2nd May 2014

Change of use and extension to create 3no. self contained apartments and 1no. maisonette. This application affects the character and appearance of Arundel Conservation Area
Arden Guest House 4 Queens Lane Arundel

Job Title	Arden Guest House		
Client	Mr & Mrs Meathrel		
Drawing Name	Proposed Elevations		
Drawing Status	Planning		
Drawn by	DF	Date	Dec 13
Checked by		Date	
Drawing Scale	1:100 at A2		
Drawing No	Status	Revision	
13519/	08

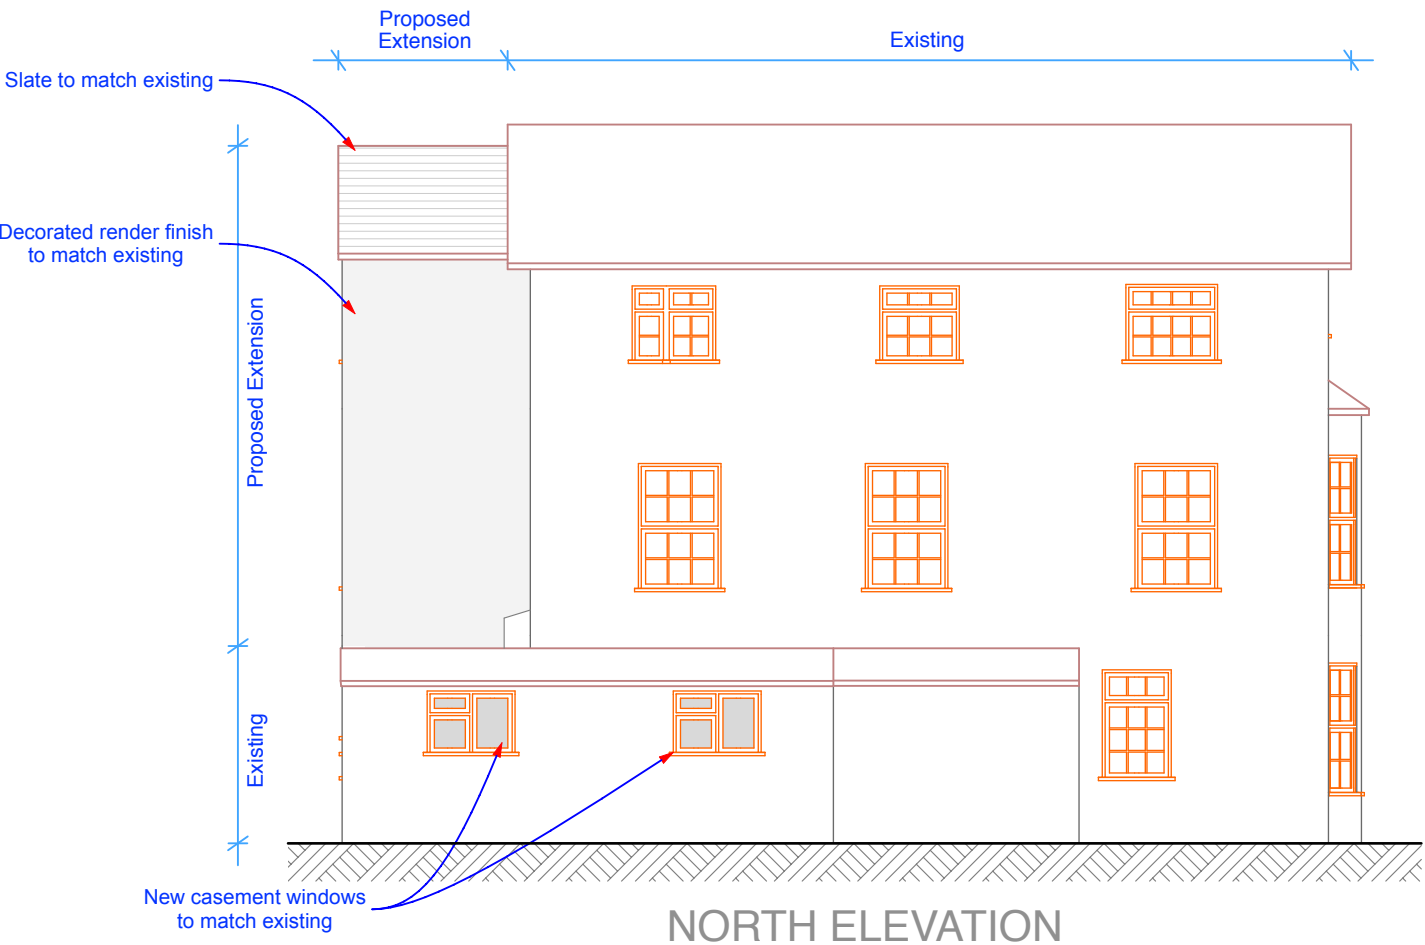
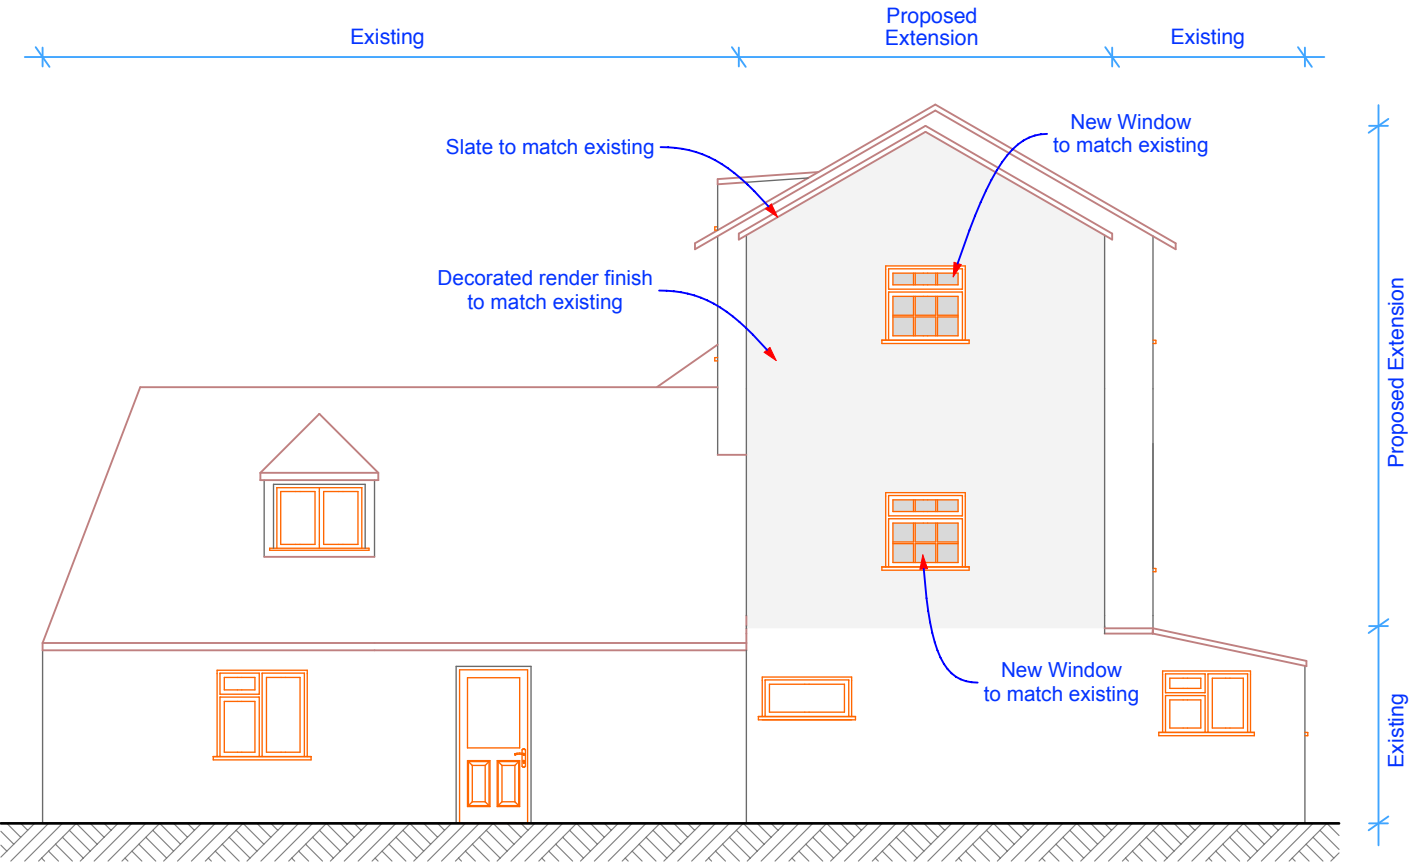
It seems that an extension to the full height of Arden Guest House roof will house a new stairwell that extends vertically from the extremity of the existing ground floor building.

Our currently enjoyed view, which reaches up to the Crossbush crest will be about halved. Not ideal, and just something I thought worth bringing to your attention.

Additionally, I would like to think that the new stairwell extension will considerably incorporate opaque glazing.
